**Port Kembla Gas Terminal – EPA Comments on Environmental Impact Statement**

I am writing in response to the Department of Planning and Environment (DPE) request of 13 November 2018 to provide advice on the exhibited Port Kembla Gas Terminal development application (DA) (CSSI 18\_9471). The proposal, if approved, will require Environment Protection Licences issued by the Environment Protection Authority (EPA) for both the construction and operational phases of the project.

Attachment 1: EPA submission on Port Kembla Gas Terminal

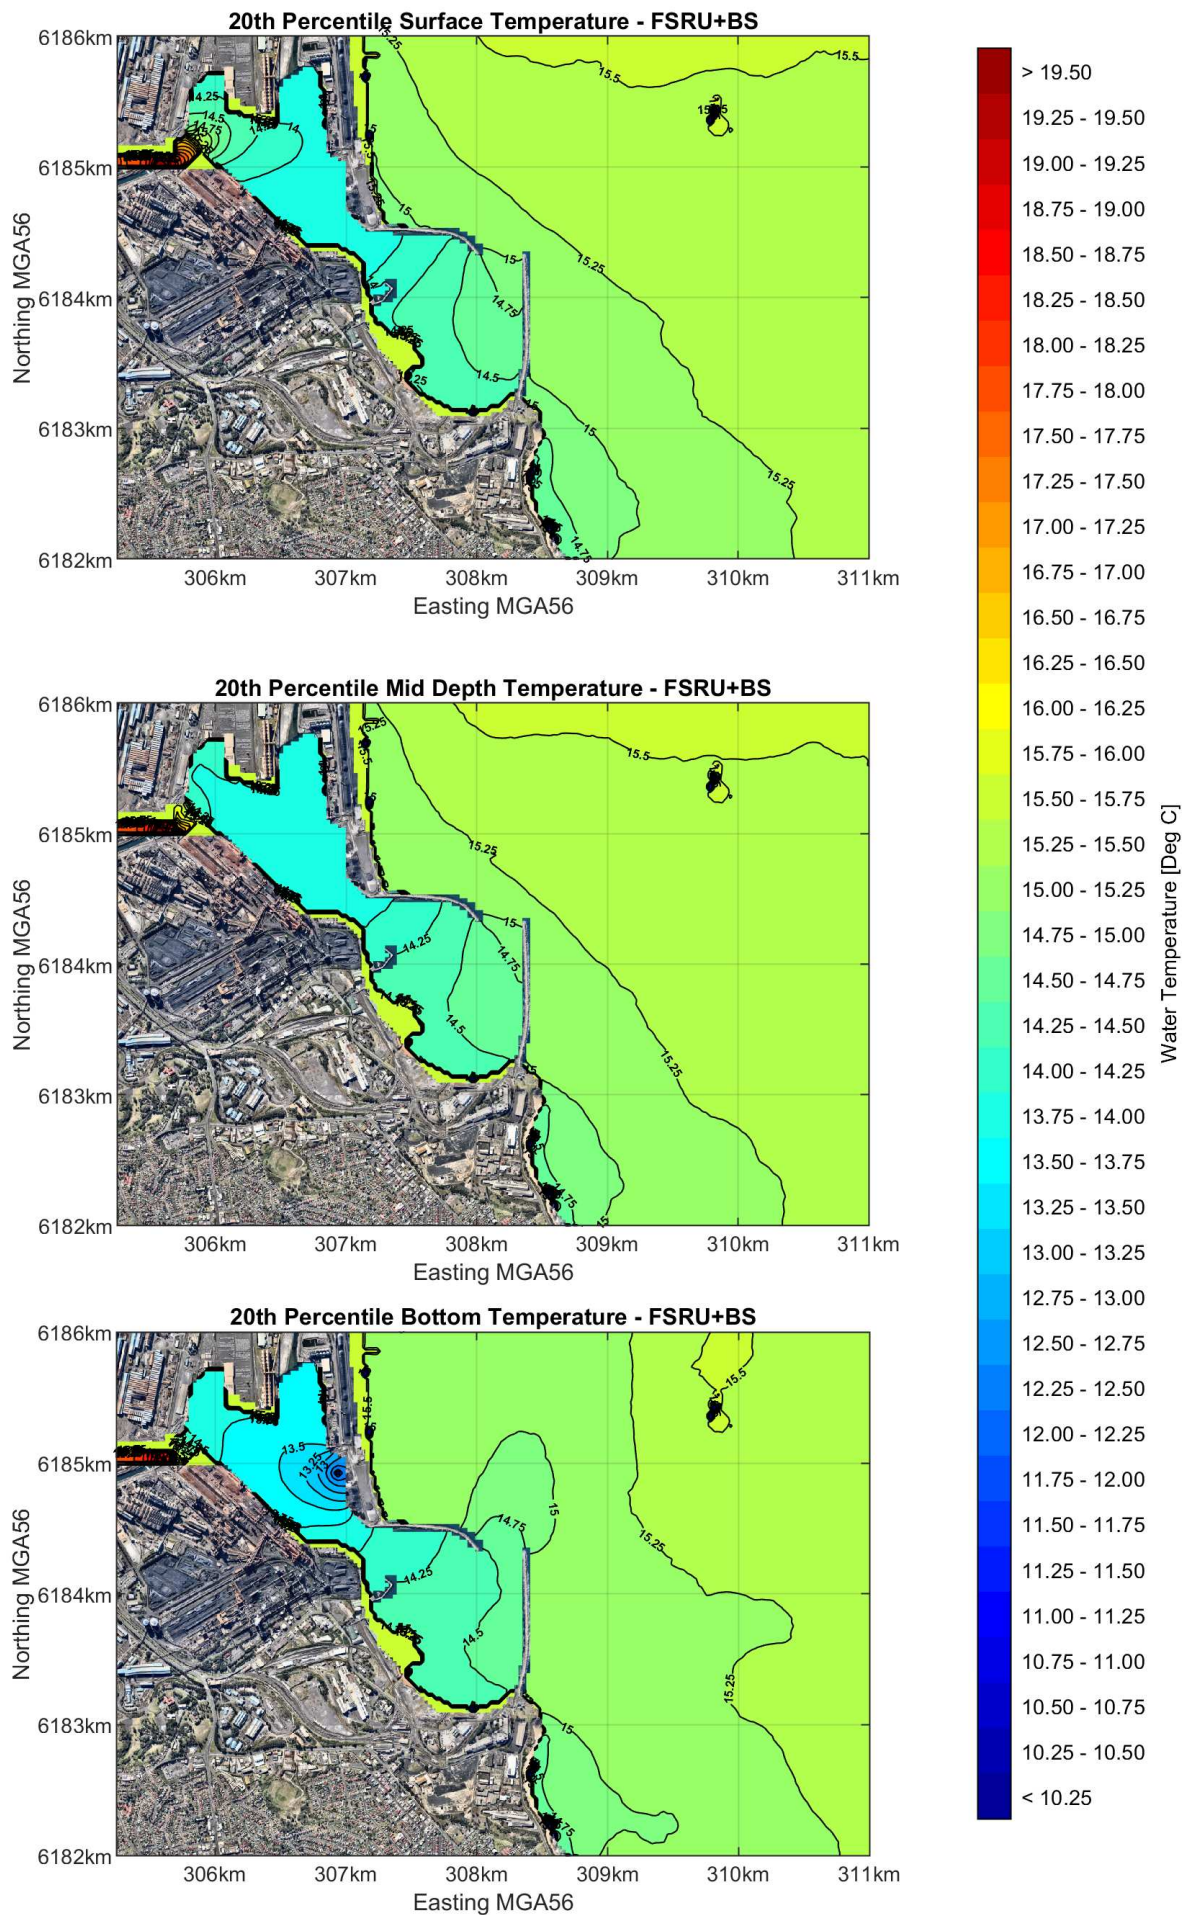
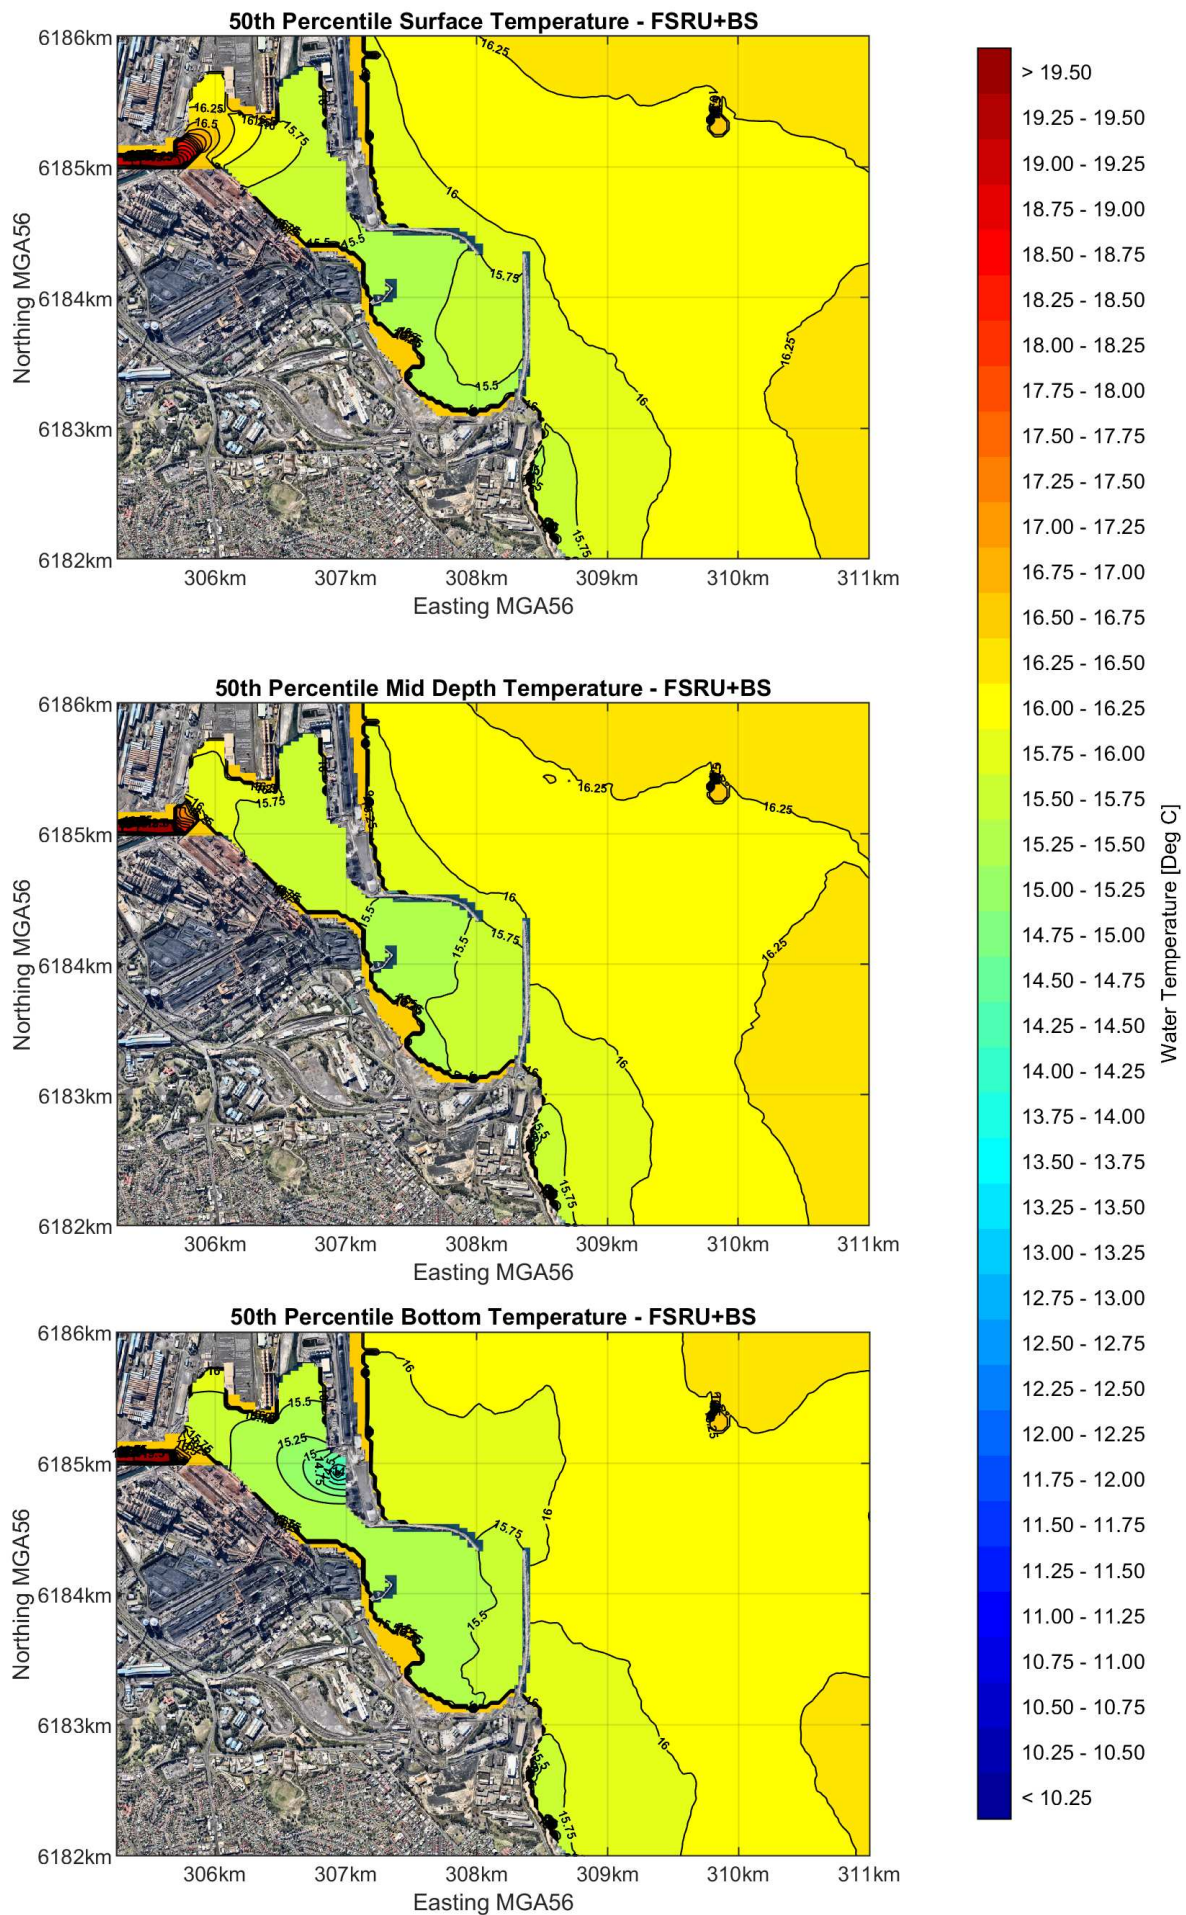
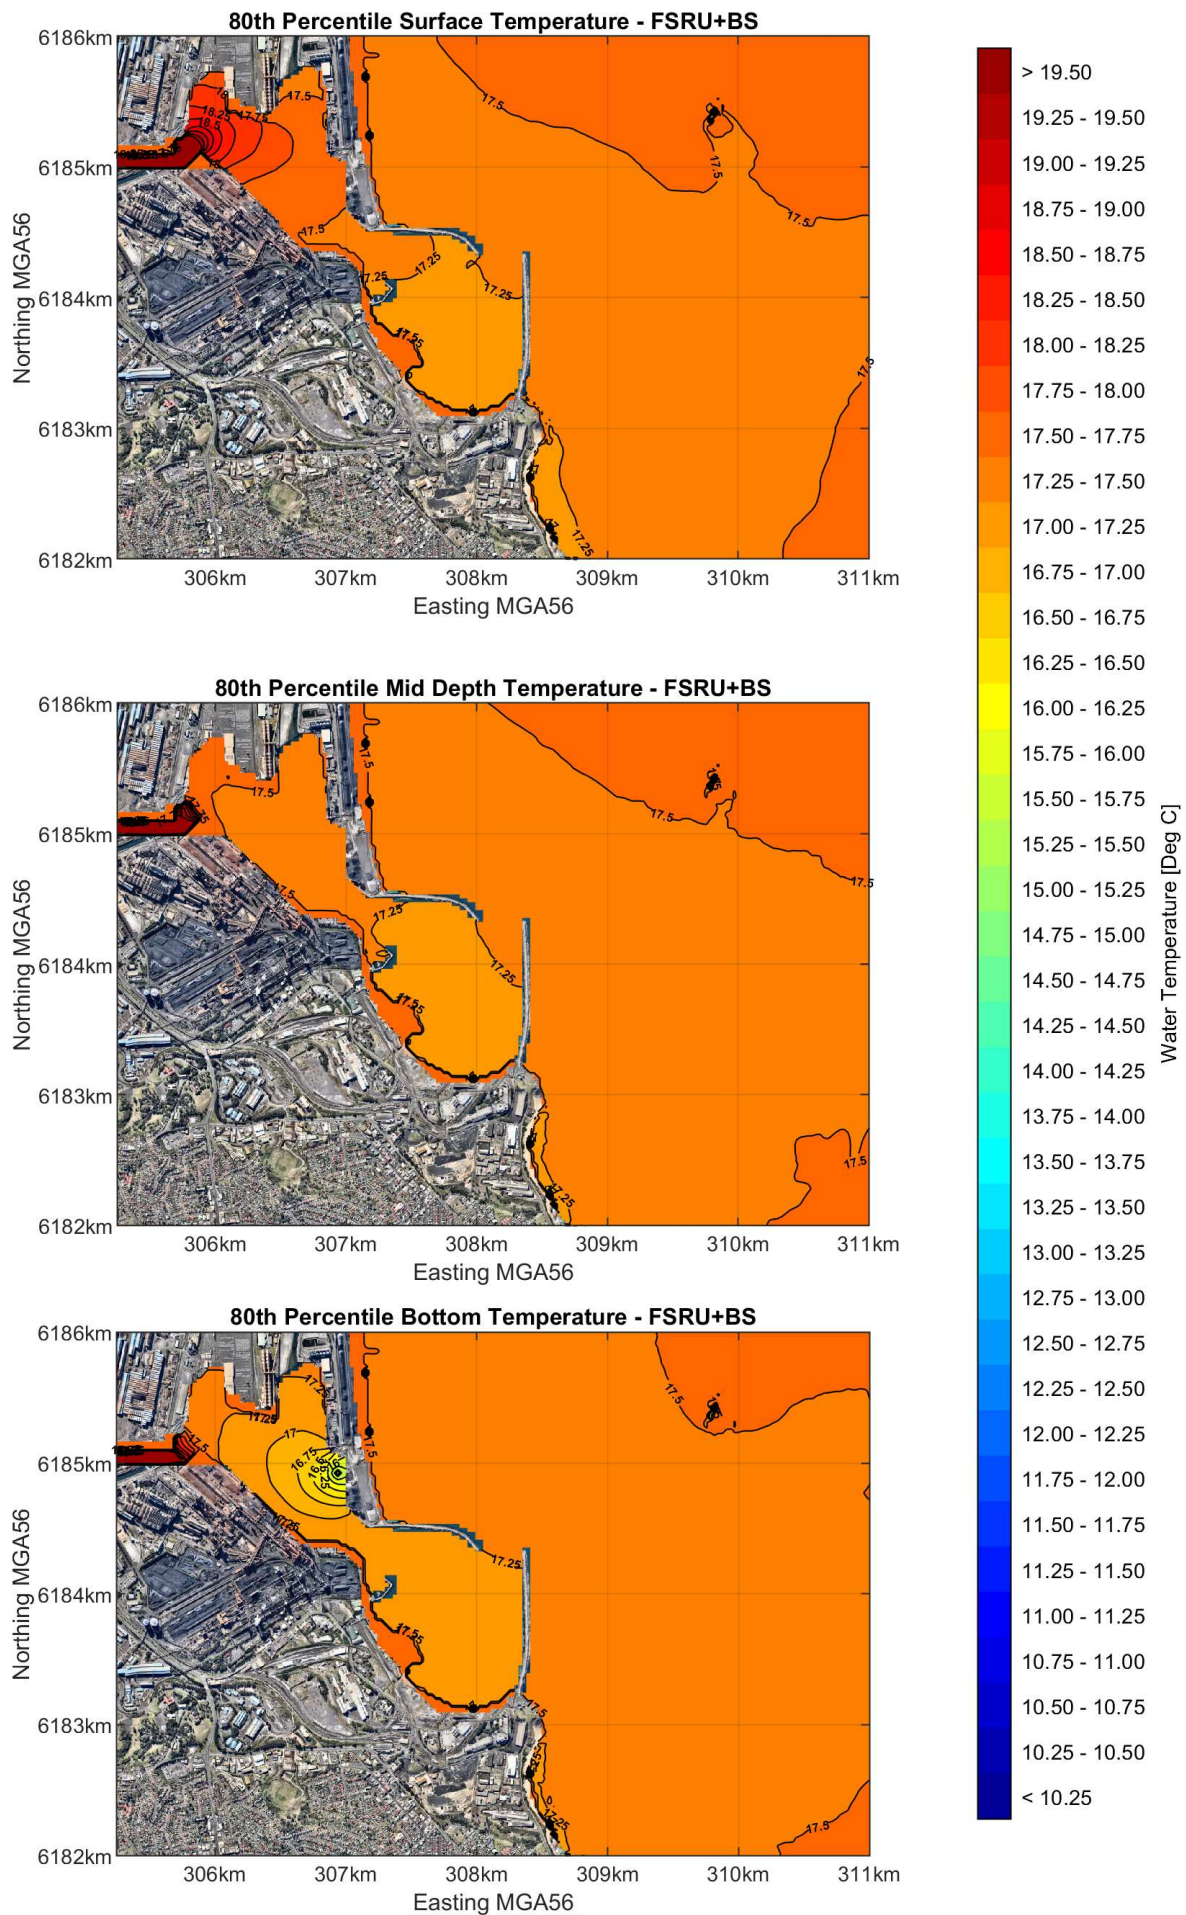
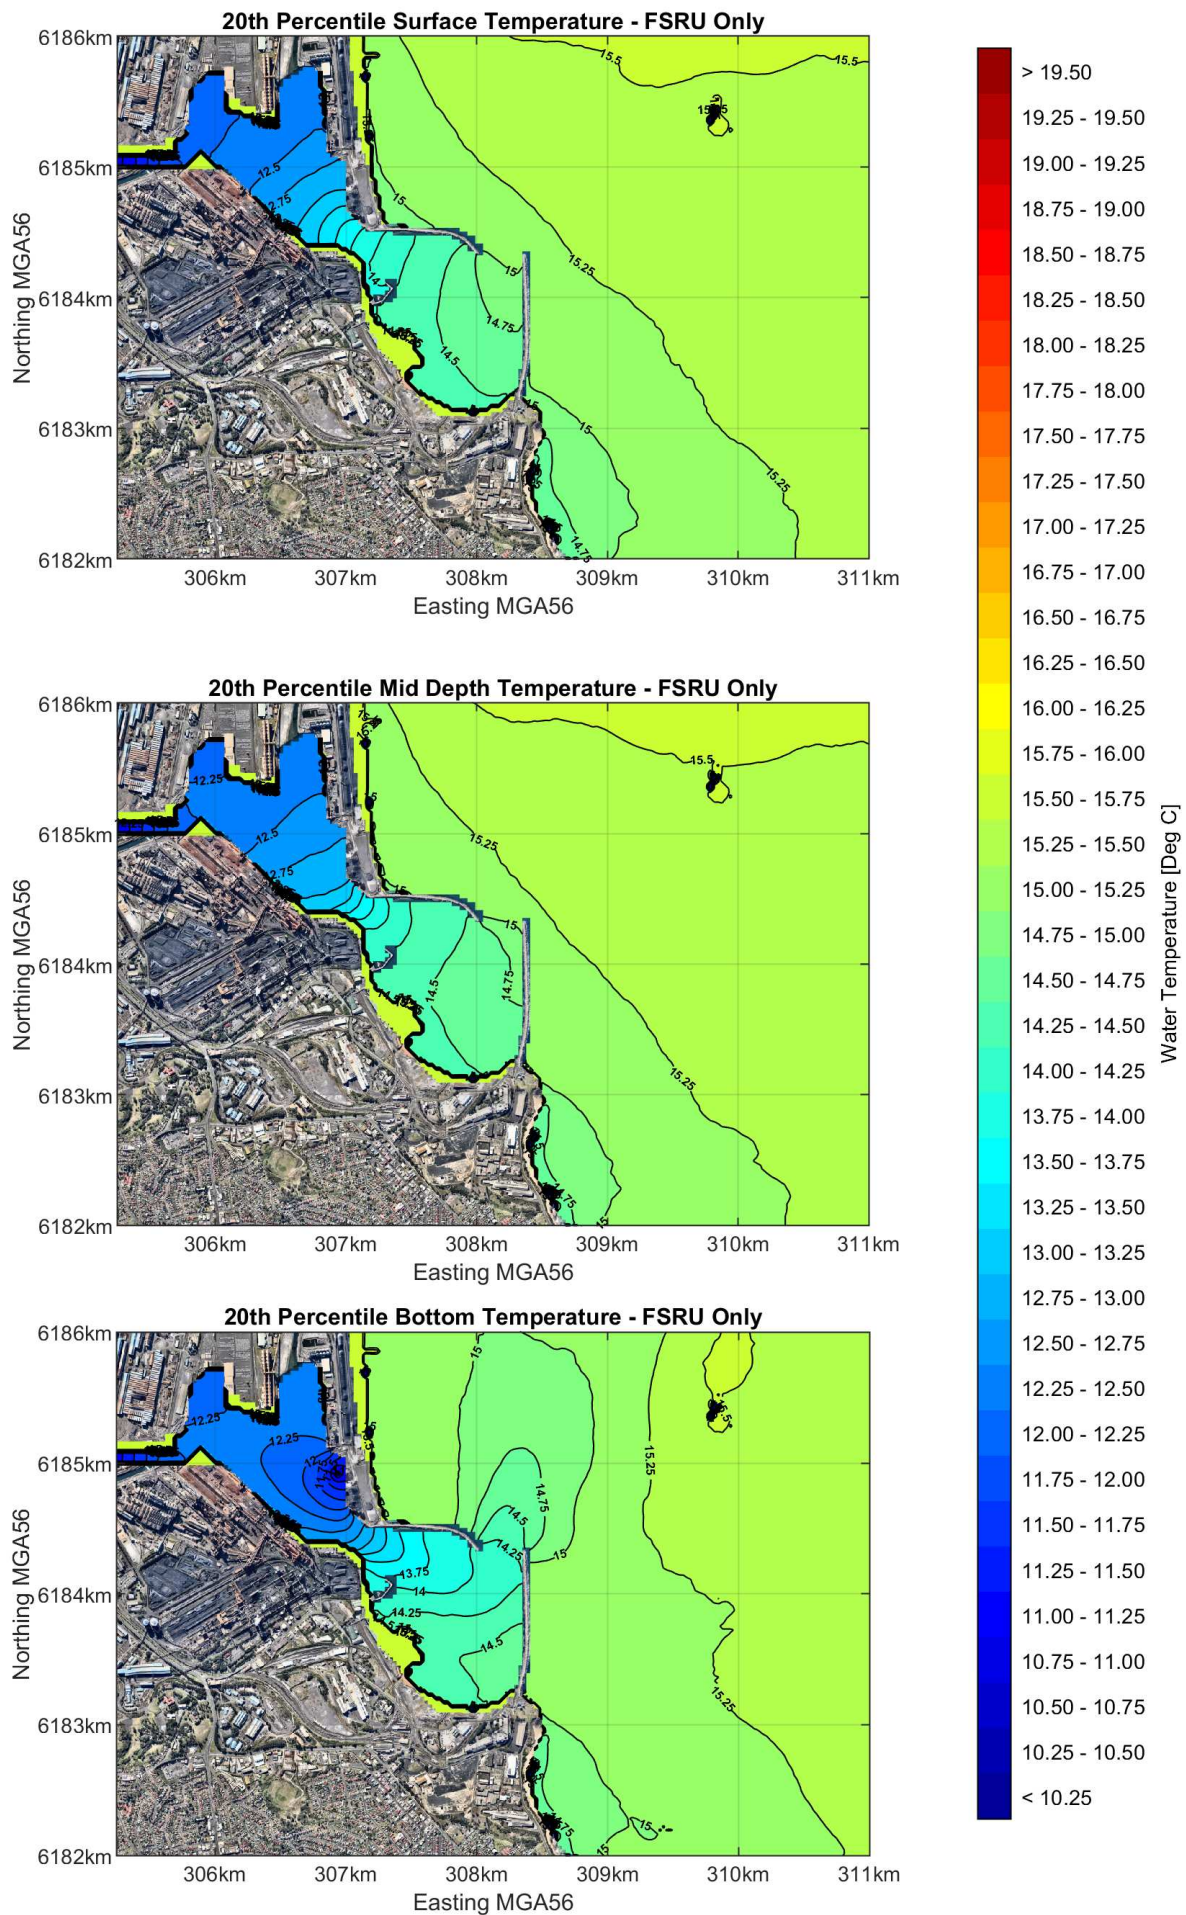
The EIS does not appear to have adequately described the impact over each season or in accordance with water quality trigger values in the Australian Water Quality Guidelines. The assessment should consider if the water quality criteria is achieved at the edge of the near-field mixing zone. The water quality guidelines for temperature decreases states, *for cold water discharges, the median temperature should not be permitted to fall below the 20%ile temperature value obtained from the seasonal distribution of temperature data from the reference ecosystem (page 8.2–67 ANZECC 2000, Vol 2).*

The resolution in the *Thermal Plume Modelling* charts (Appendix F) provided is limited and the associated temperature scale should capture the minimum modelled temperature, and not just, *less than 16.5 degrees Celsius*.

- details on the full range of modelled water temperatures.
- where potential impacts do not meet WQOs at the edge of the near field mixing zone, further practical mitigation measures that can be taken to mitigate the impacts of the pollution must be assessed, including but not limited to:
